3B Canning Cross is a 21st century terraced house in South London, upper Camberwell Grove Conservation Area. It is a key unlisted building.

4.0 Pre-application response

4.1 Feedback from Pre-App:

Proposed Second Floor Plan
Scale: 1:50

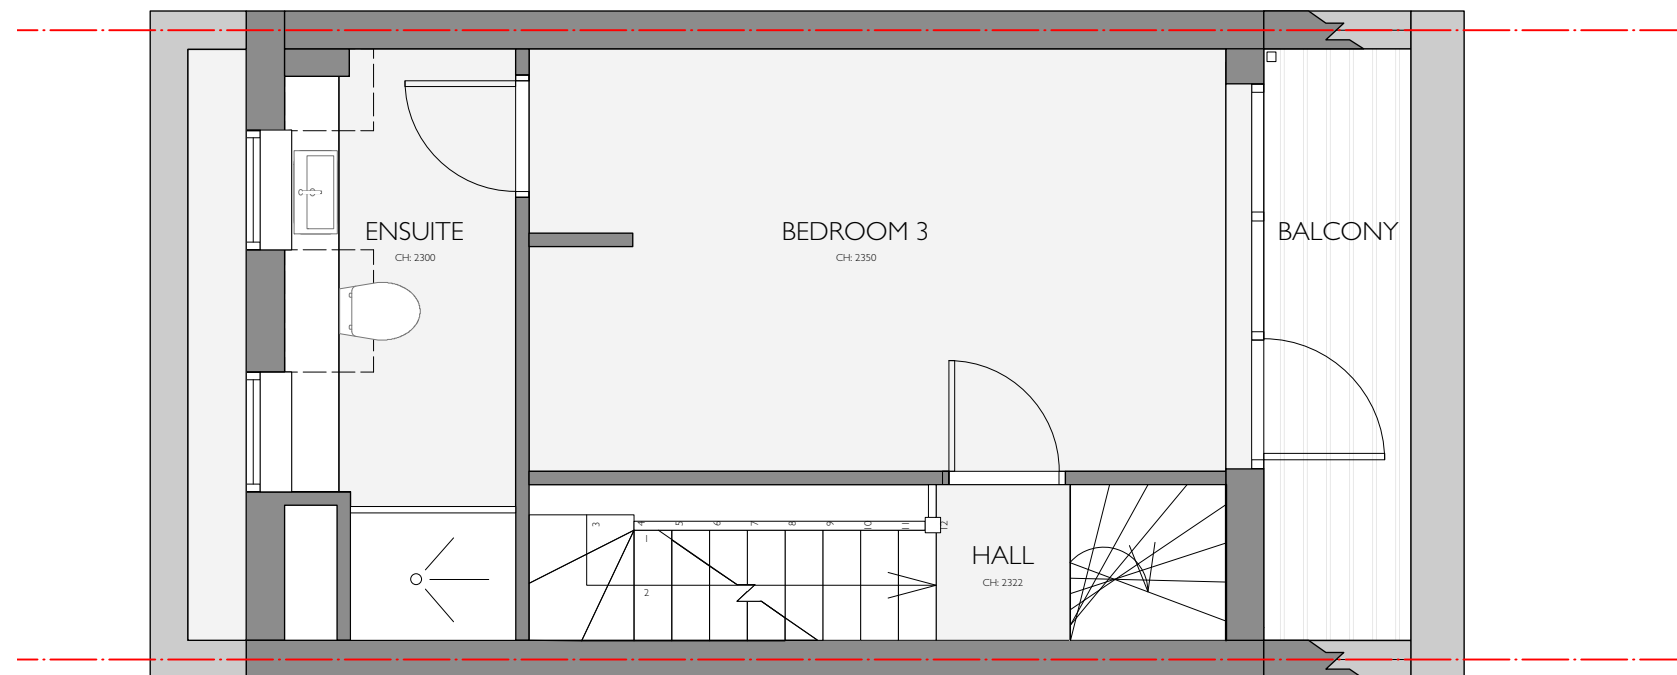
1. Loss of privacy: The proposal raises significant privacy concerns in respect of No 28 on the opposite side of Canning Cross.

2. Daylight/Sunlight: [care to be taken not to impact] sensitive windows on the opposite side of Canning Cross

Our response: we have updated the glass at the front of 3B Canning Cross to be frosted, and significantly set back.

Our response: we have set back the balustrade from the edge of the roof. This passes the 25° light test.

Current proposal: balustrade set back 2m from edge.
